Our Ref: EP/145/17/HH
Your Ref:

Town & Country Planning Act 1990 (as amended)
Town & country Planning (Development Management Procedure) (England) Order 2015
Application for Planning Permission for Works or Extension to a Dwelling

Development Extend garage & form pitched roof over. Single storey infill extension between enlarged garage & house. Formation of enlargement to existing dormer on SE elevation & addition of pitched roof to existing dormer on NW elevation. Removal of tile hanging from gables & dormers & fitting fibre cement weather board.

Location 9 Nursery Close EAST PRESTON

**Proposed Ground Floor
and Site Plans**

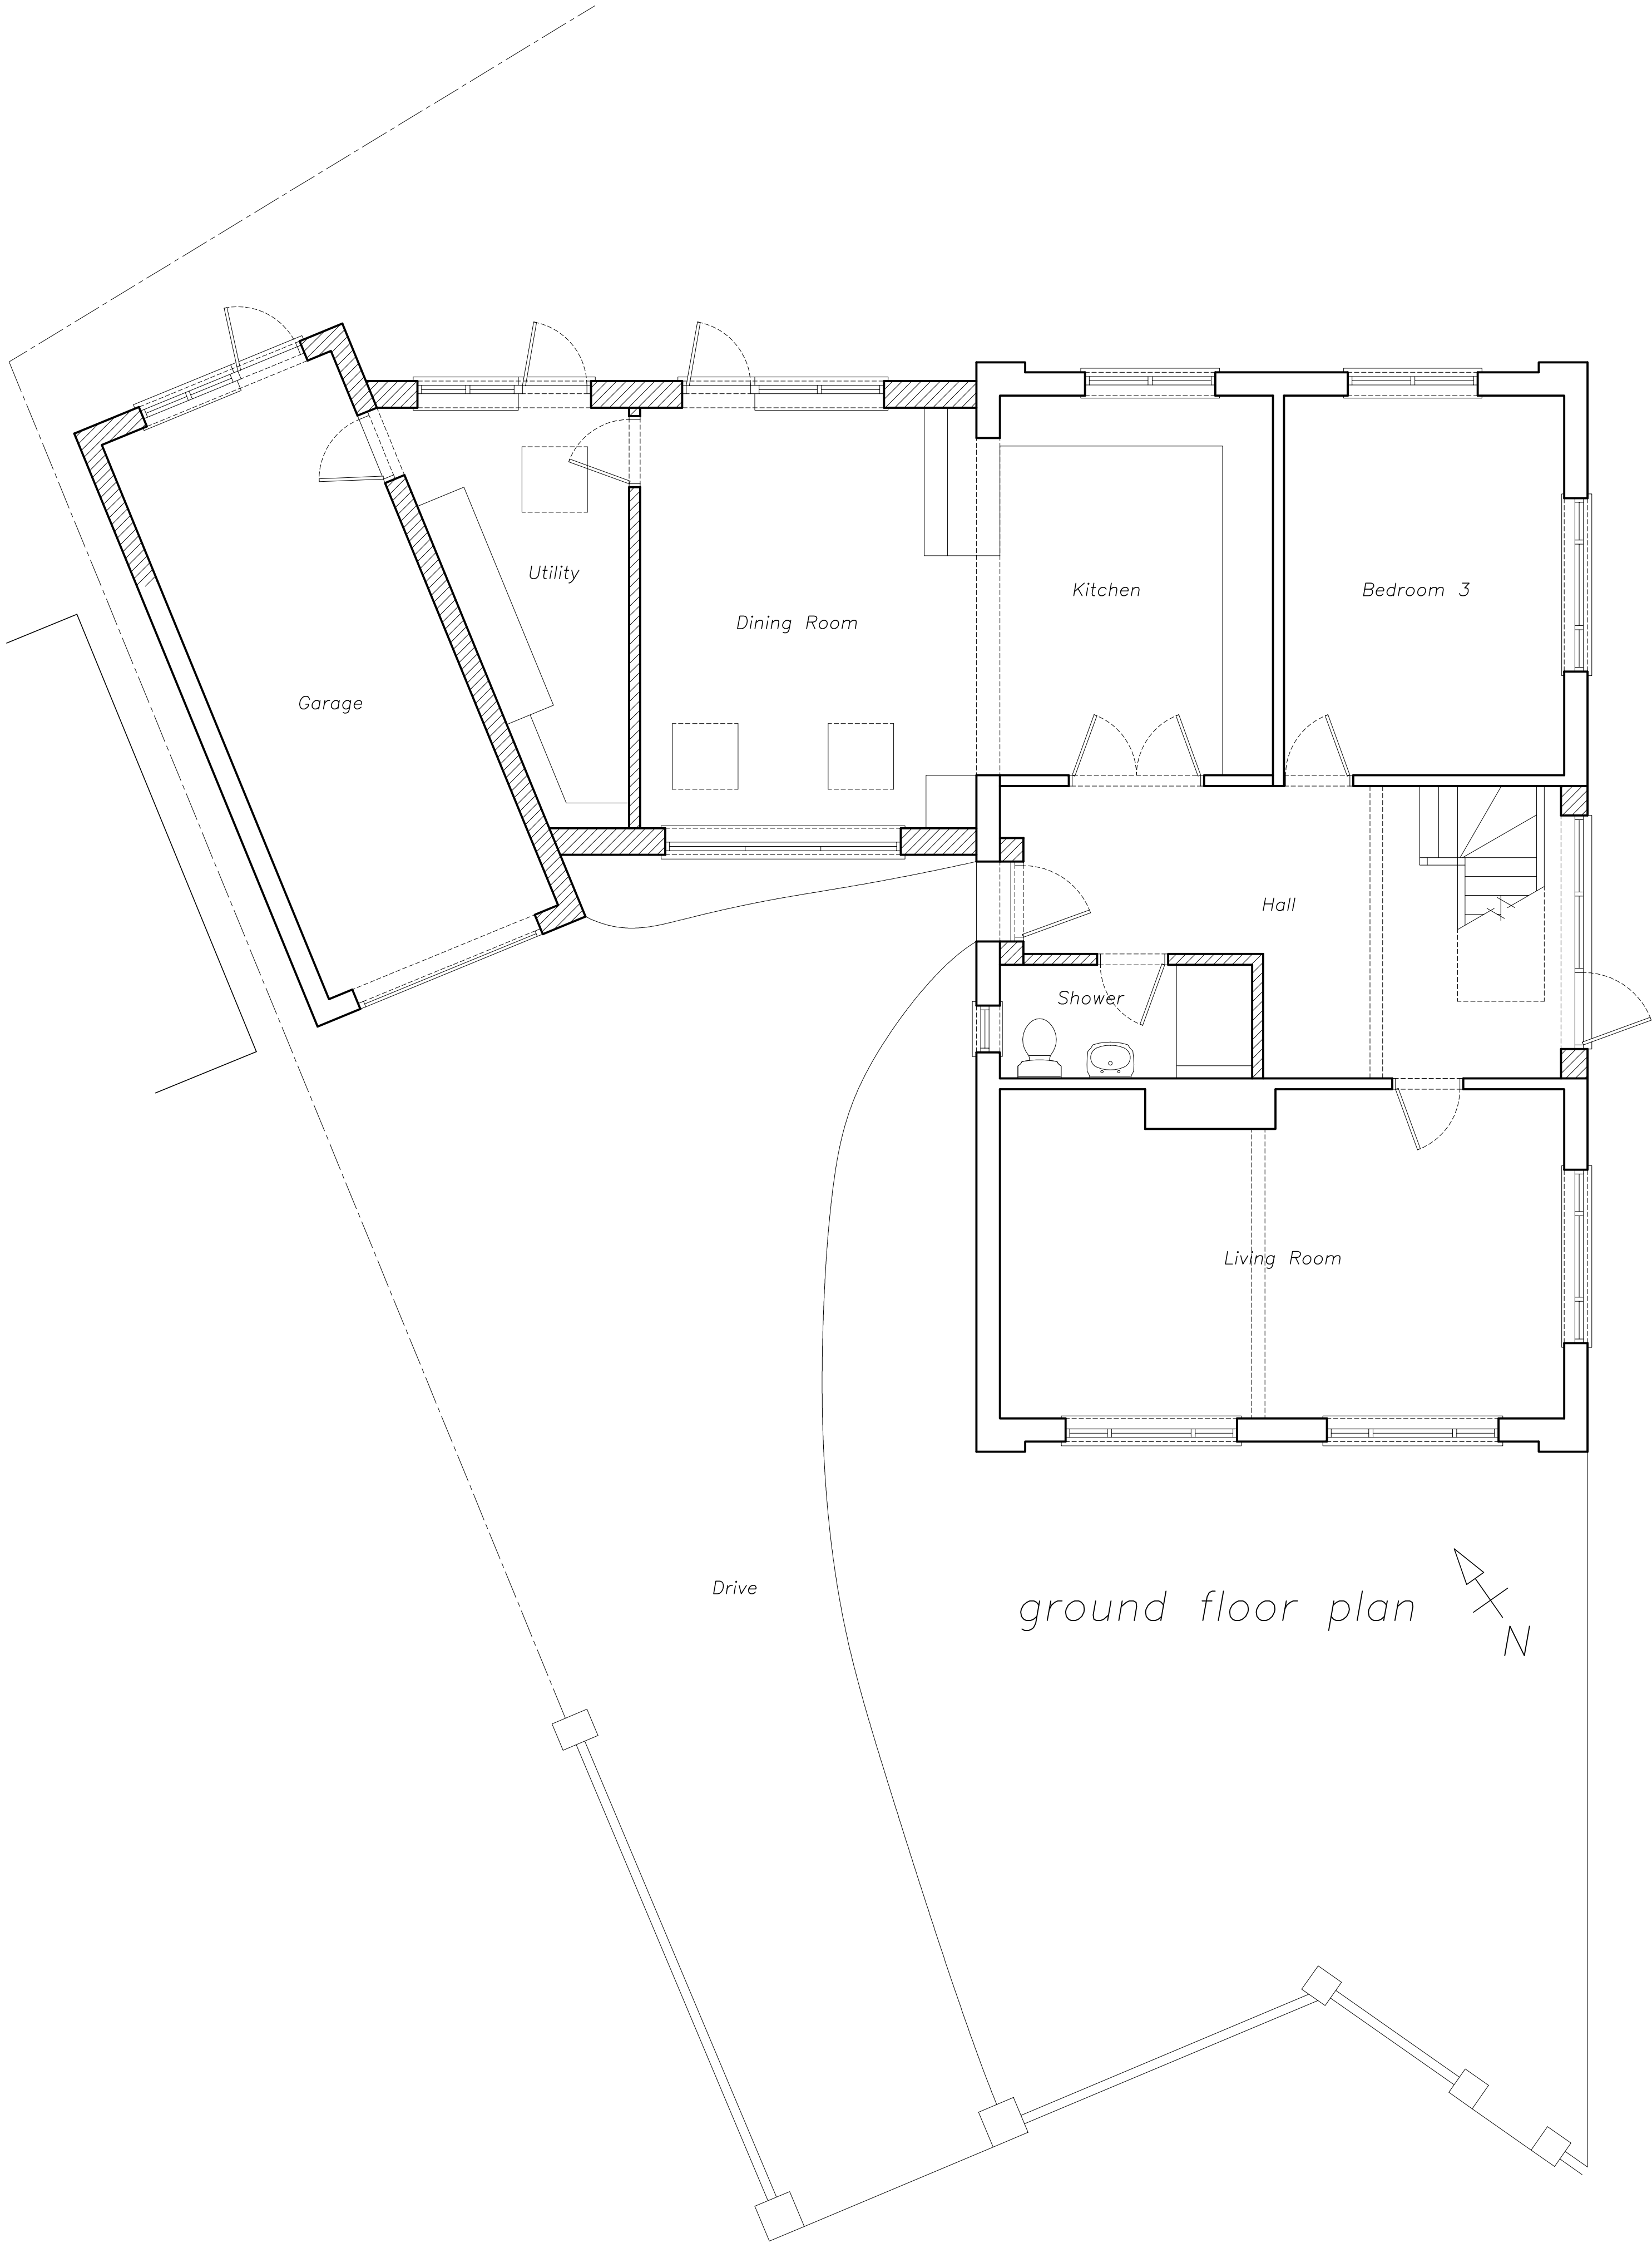
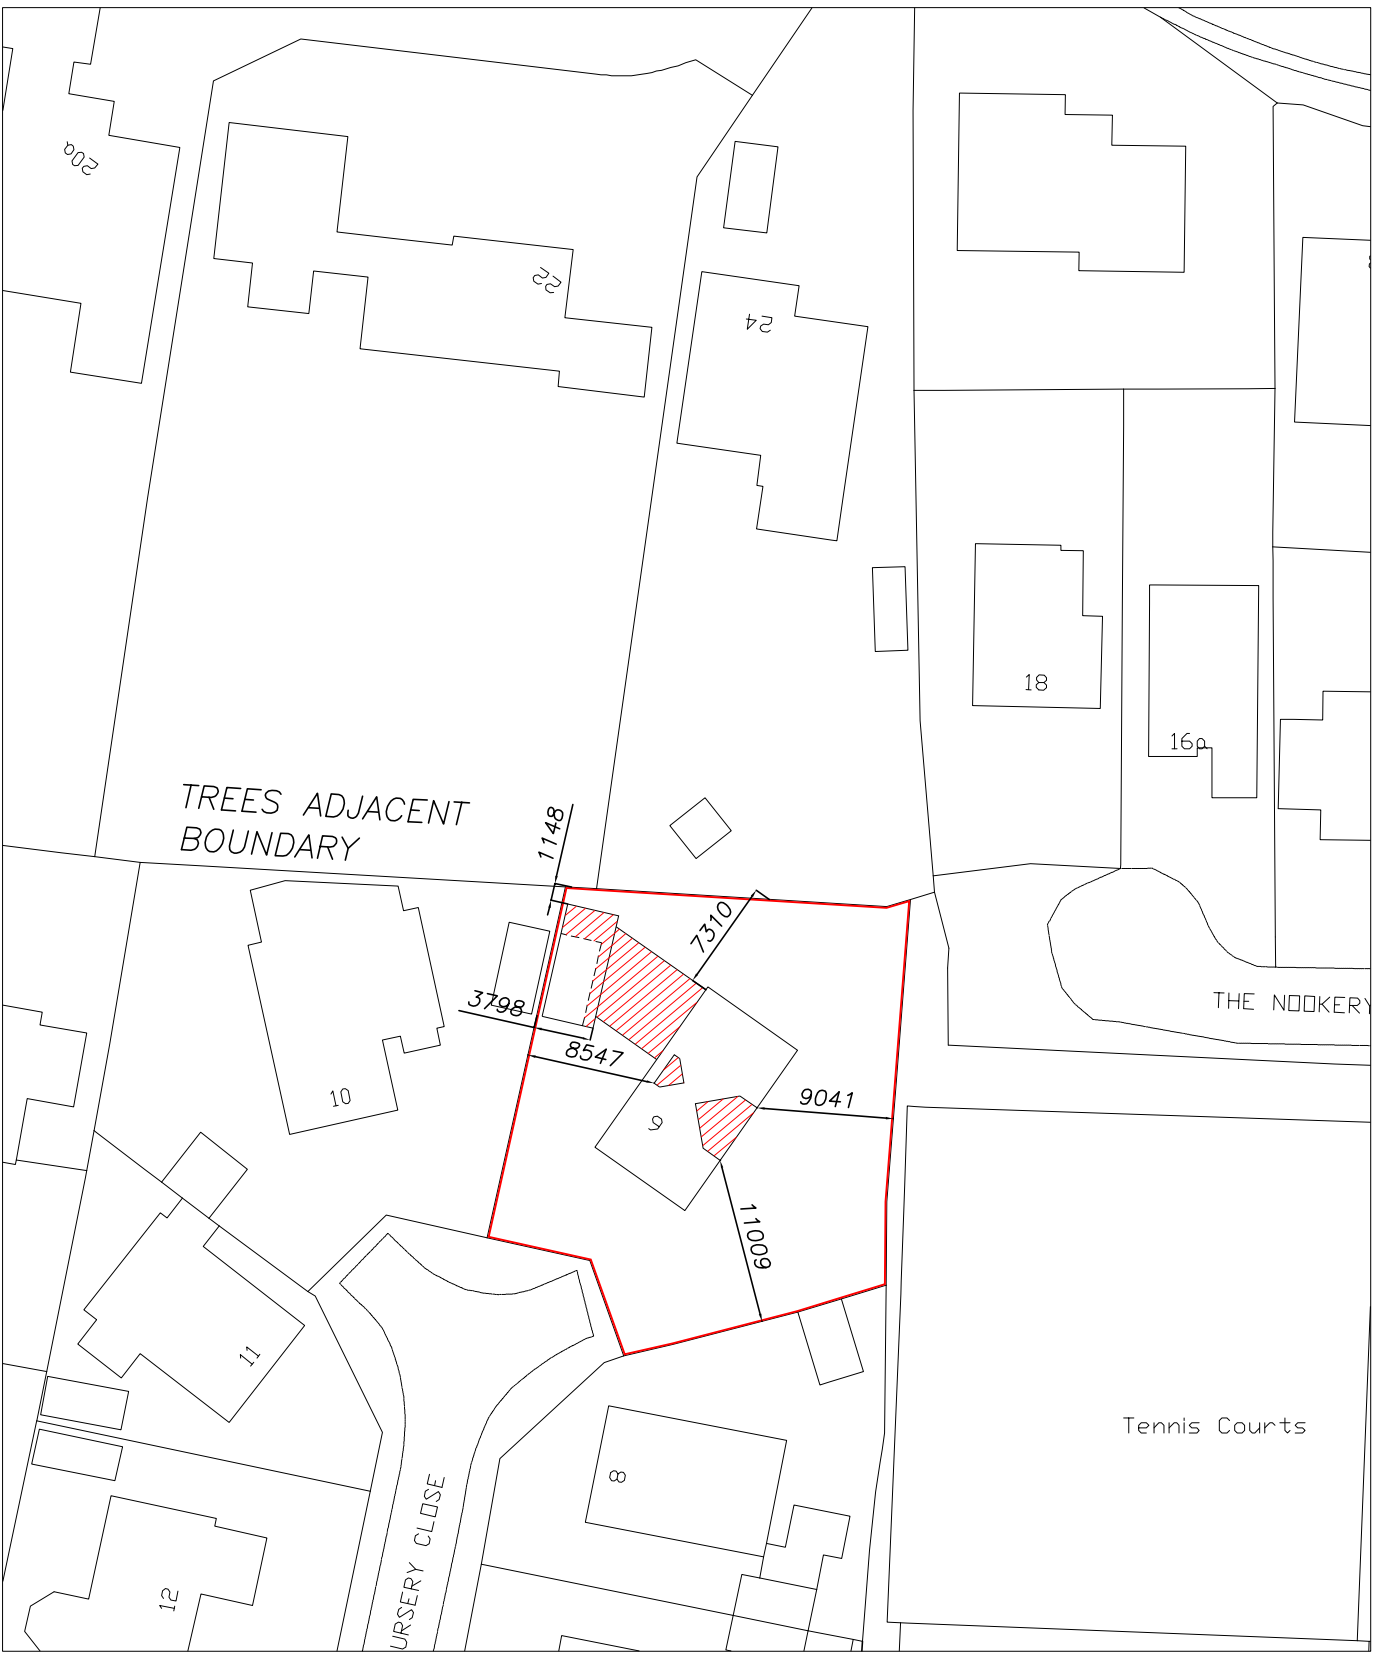
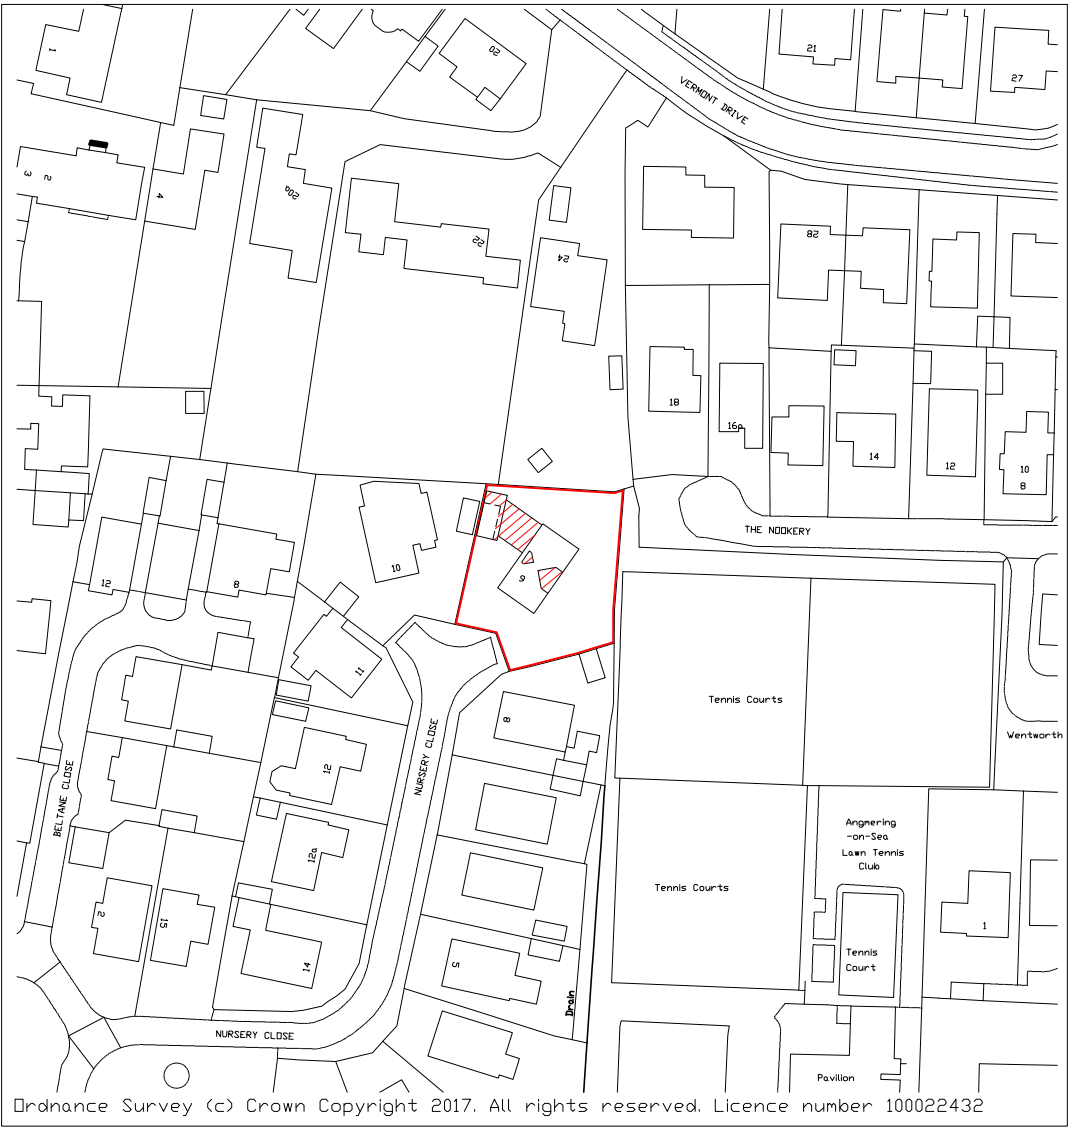
Please forward amended block plans showing the measurements from the proposal to the boundaries
